Memorandum ABP-316178-23 – Request for Further Information

To: Una Crosse, ADP
From: Alaine Clarke, Inspector
Re: Proposed development of Oweninny Windfarm Phase 3 consisting of 18 no. wind turbines within the townlands of Laghtanvack, Croaghaun (also known as Croaghaun West), Moneynieran, Corvoderry, Shanvolahan, Dooleg More, Shranakilly, Bellacorrick and Shanvodinnaun, Co. Mayo.
Date: 3rd October 2024

Overview Sheet

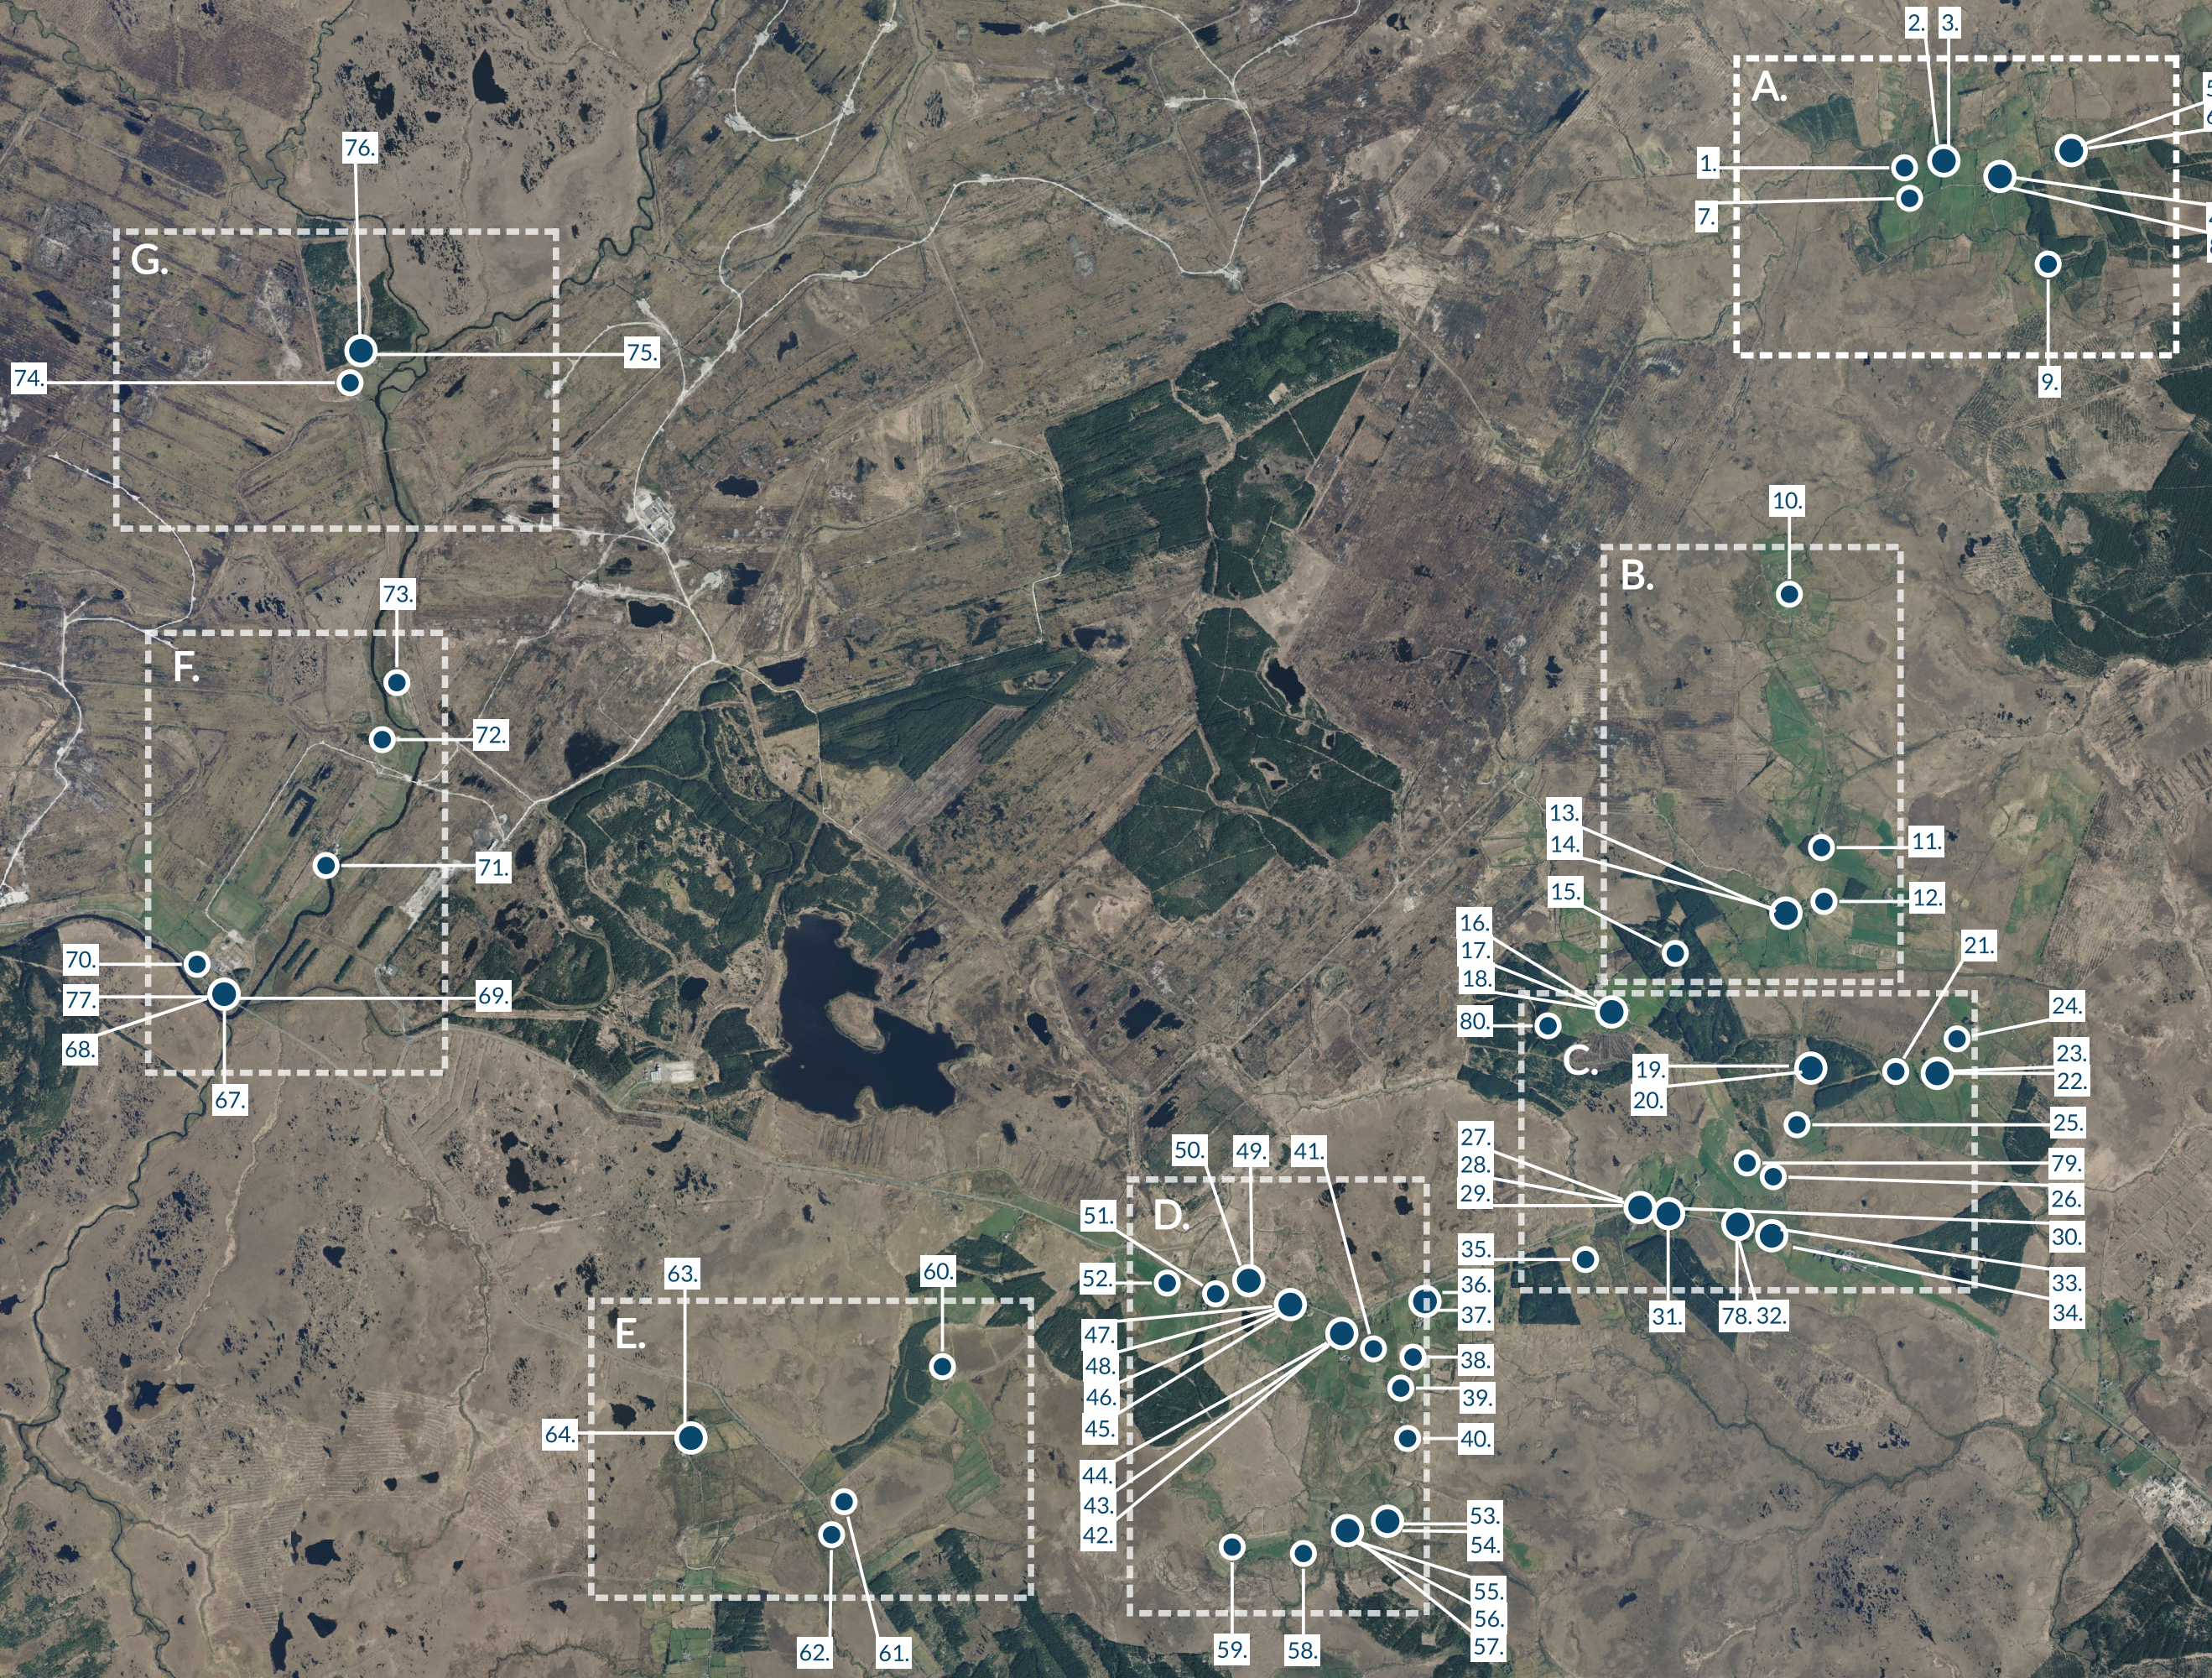
Shadow flicker is assessed in Chapter 14 of the EIAR. Receptors are stated to be detailed in Figure 10.1 however there are no Figures in this chapter (Figure 10.1 relates to a site location map in the hydrogeology chapter).

Chapter 6, Figure 6.2 includes a map of sensitive receptors. These are not labelled but are a series of dots.

Table 6.3 presents a summary of identified receptors i.e. total number of SR of commercial, residential, both and unknown. No coordinates are provided, nor are they labelled in any map in the planning documentation.

Having regard to the foregoing, I consider it necessary that the applicant provide both the ITM and Eircode of each of the 78 shadow flicker receptors with an annotated map indicating each of the receptors.
